The Member-Secretary,
Madras Metropolitan
Development Authority,
8, Gandhi-Irwin Road,
Madras: 600 008.

Letter No. B1/21296/94

Sub: MMDA-APU-PP Condn of G/F+3F residential
buildg at D.No 23 R.A Puram IIIrd Main rd
R.S.No 3968/71 of Mylapore Ms. Resubmission of
charges - reg

SITE CUM GROUND FLOOR PLAN

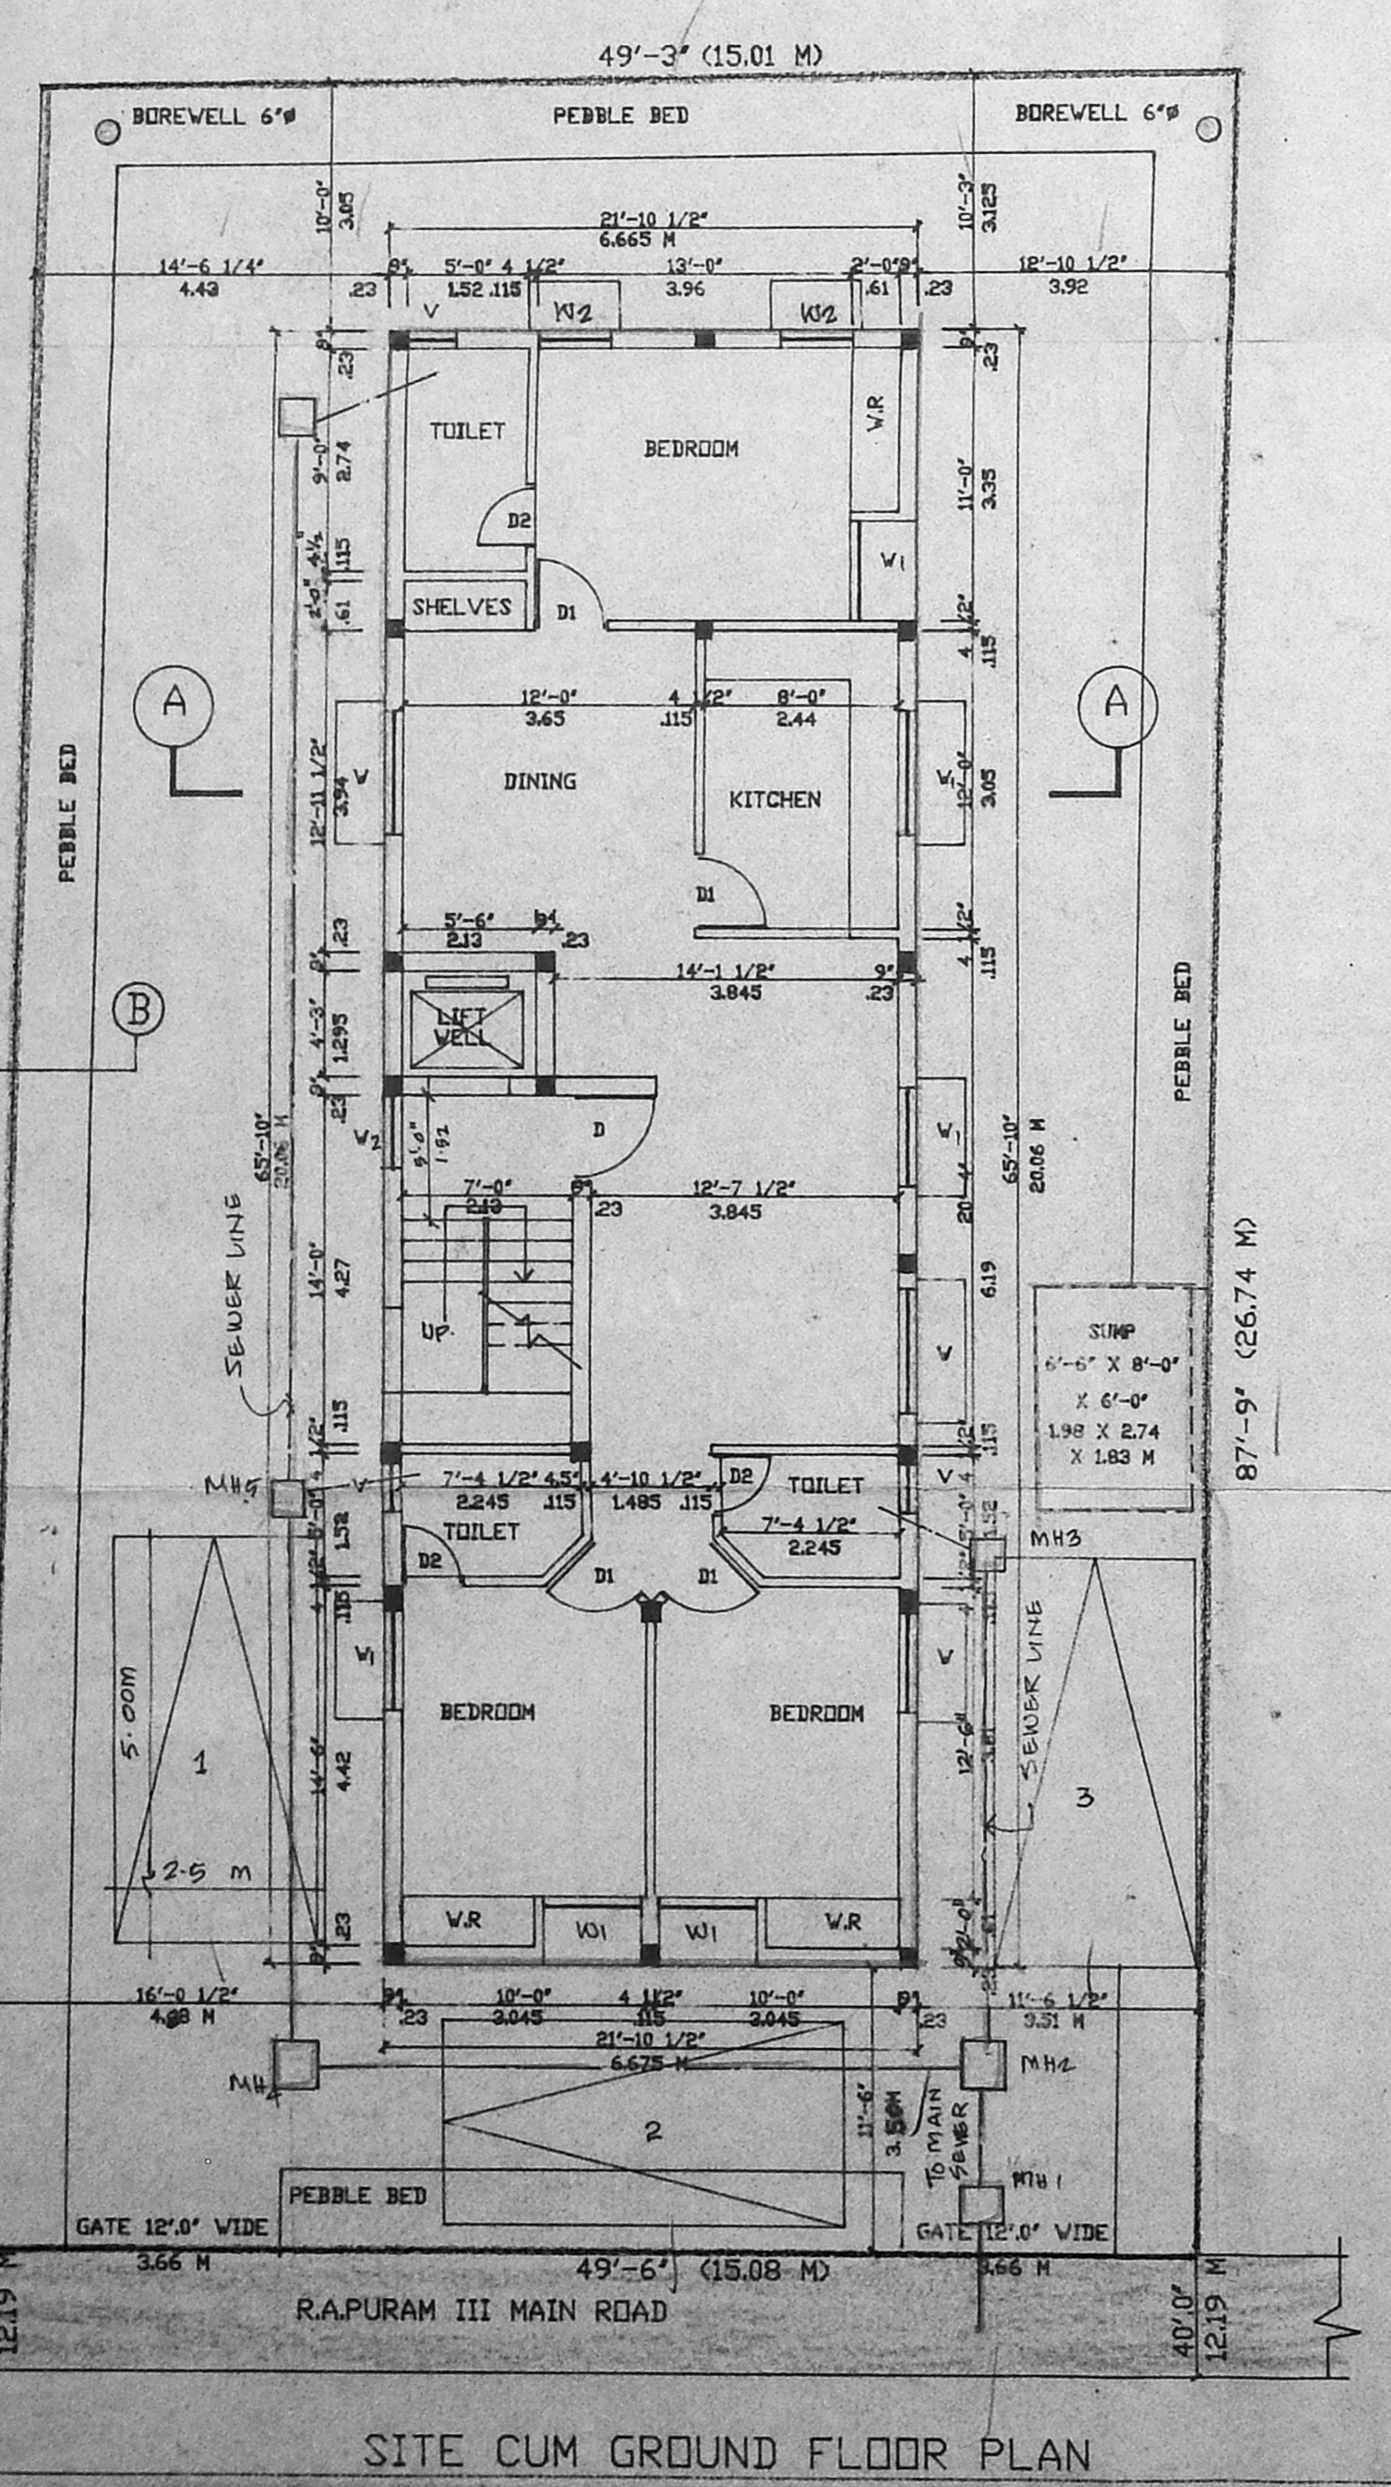
① 1) Five copies of RP showing the FSB at 3.50m
